From: Maria Tomalova
Sent: 20 August 2019 11:56
To: Nicola Spencer
Subject: FW: BR/154/19/PL, 8 Mead Court

SITE PLAN - 1/500

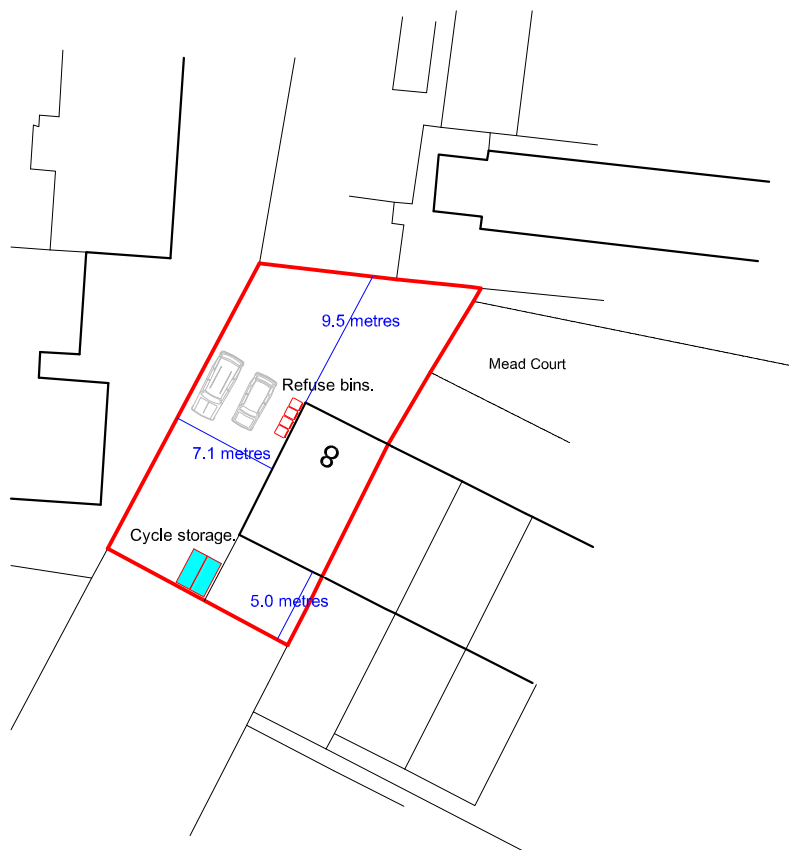
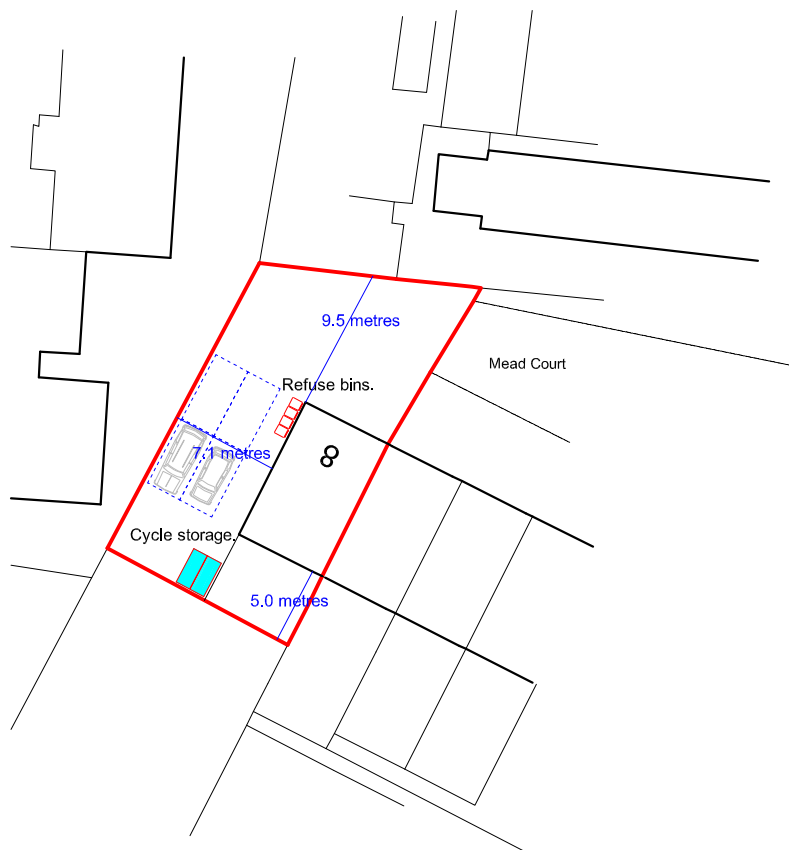
One of the grounds was a lack of parking spaces provided.
I have been on the site and the site is big enough to accommodate 4 cars,
What is a requirement for 8- bed HMO.

It would be helpful if you can demonstrate the provision of 4 parking spaces.

The site as you will know is more than capable of taking twice the amount, however, I attach a copy of a revised site plan indicating 4 x spaces as requested – I trust that this is ok?
